Town & Country Planning Act 1990 (as amended)
Town and Country Planning (Development Management Procedure) (England) Order 2015
Application for Planning Permission

Development Two storey extension. This application affect the character & appearance of the East Street Conservation Area & may affect the setting of Listed Buildings.

Location 53 East Street Littlehampton

Location Plan

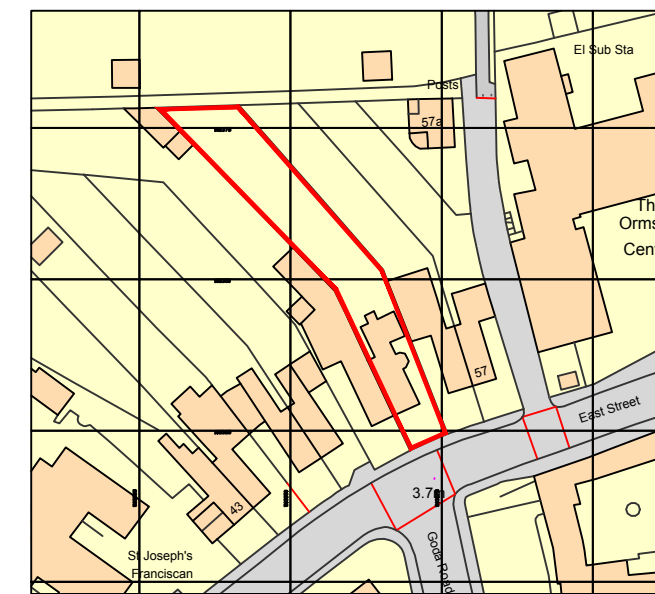
Location Plan Amend

Please submit 1 electronic or 3 paper copies of a location plan at a scale of 1:1250 or 1:2500 for rural areas. Further details of what must be included on the plan can be found in the National Validation Requirements. Please provide two named road on the existing and proposed Location plans.
